FULL

Reference:	H04-0165-17	Date of Decision:	18th April 2017
Applicant:	Mr Keith Edge 2 Quadring Road Donington Spalding Lincs PE11 4TB		
Location:	2 Quadring Road Donington Spalding		
Description:	Replacement of Sash windows to the front of the house

Project - Q32211	
Drawing No	2
Scale	As shown on A3

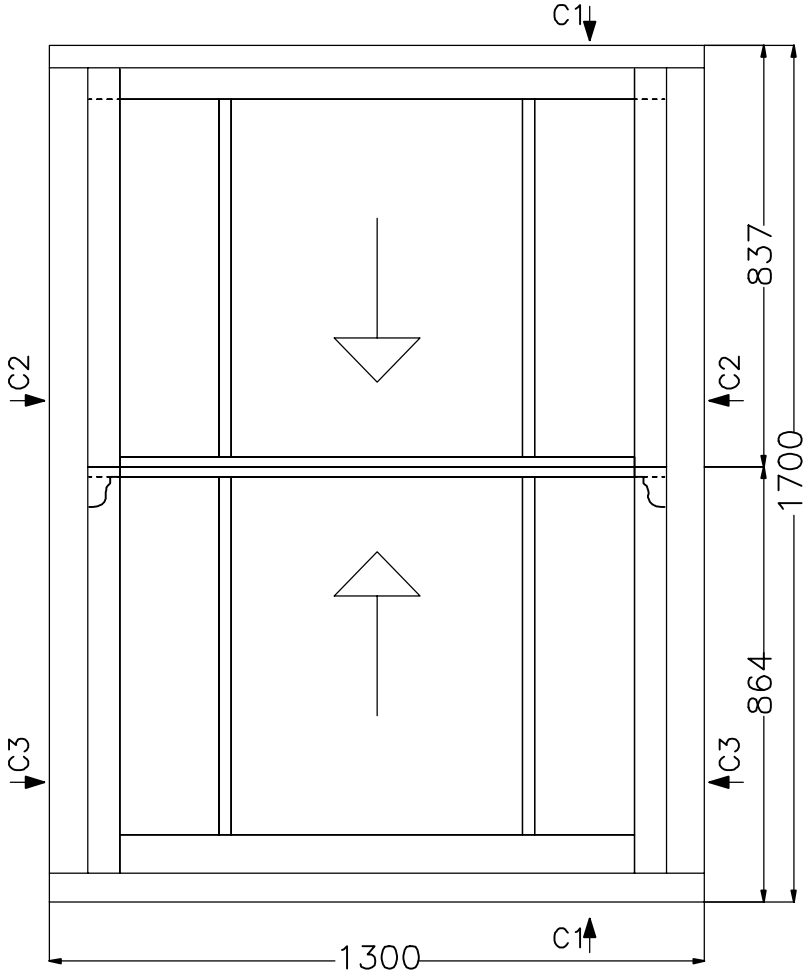
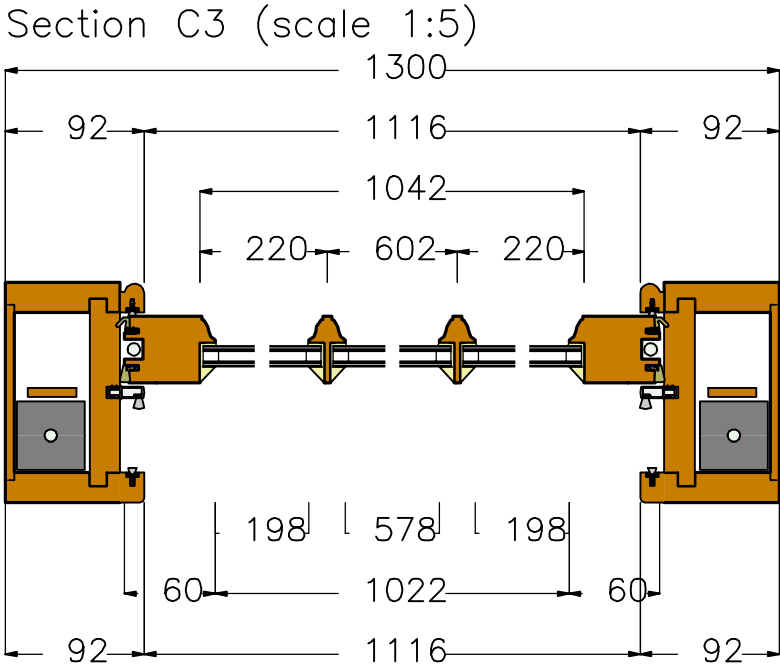
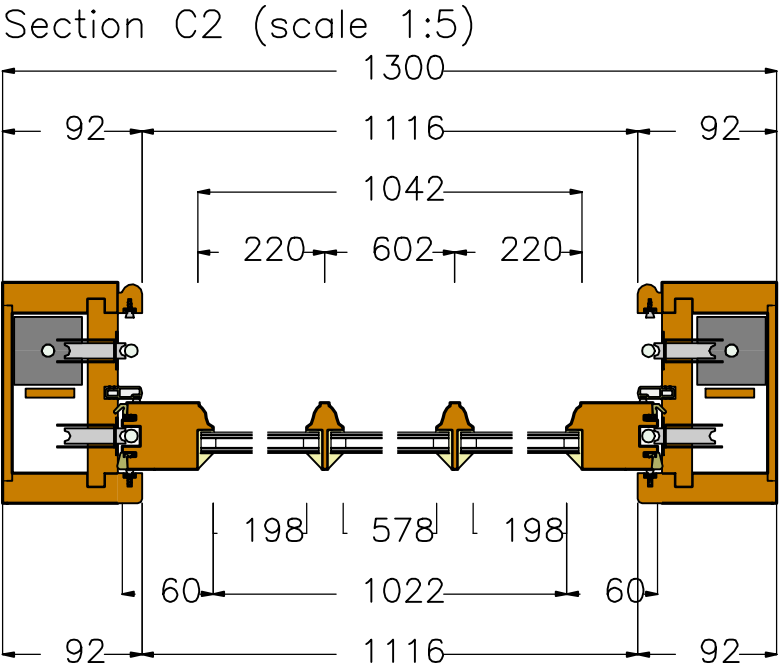
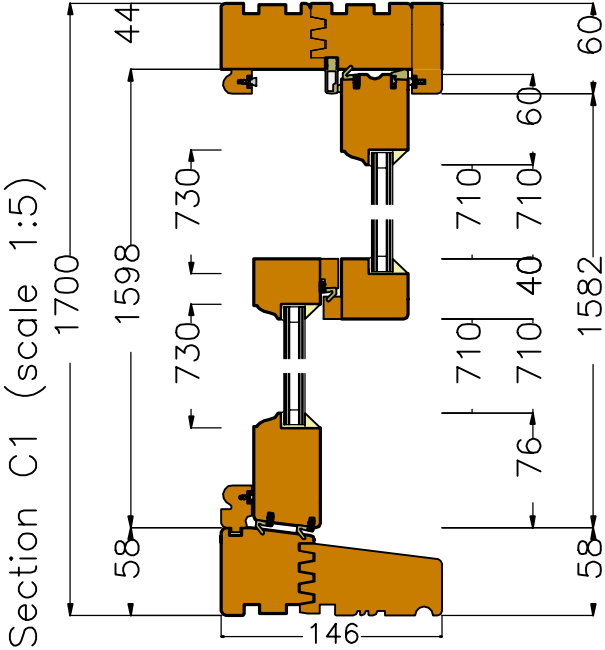
- 1 The property is subject to an Article 4 Direction. The purpose of the Direction is to protect the traditional surviving fabric that remains. The proposal seeks to remove this fabric and replace with upvc. Upvc is not a traditional, vernacular material and as such is unsuitable for use in traditional buildings in Conservation Areas.

The Council seeks to use the controls that are available in order to ensure wherever possible that development preserves and enhances the character and appearance of the District's conservation areas. The installation of white upvc windows in a traditional building has an unacceptably harmful impact. The alien appearance of modern plastic material in a traditional building undermines the character and appearance of the conservation area. As such, it would be contrary to national guidance set out in Section 12 of the National Planning Policy Framework 2012.
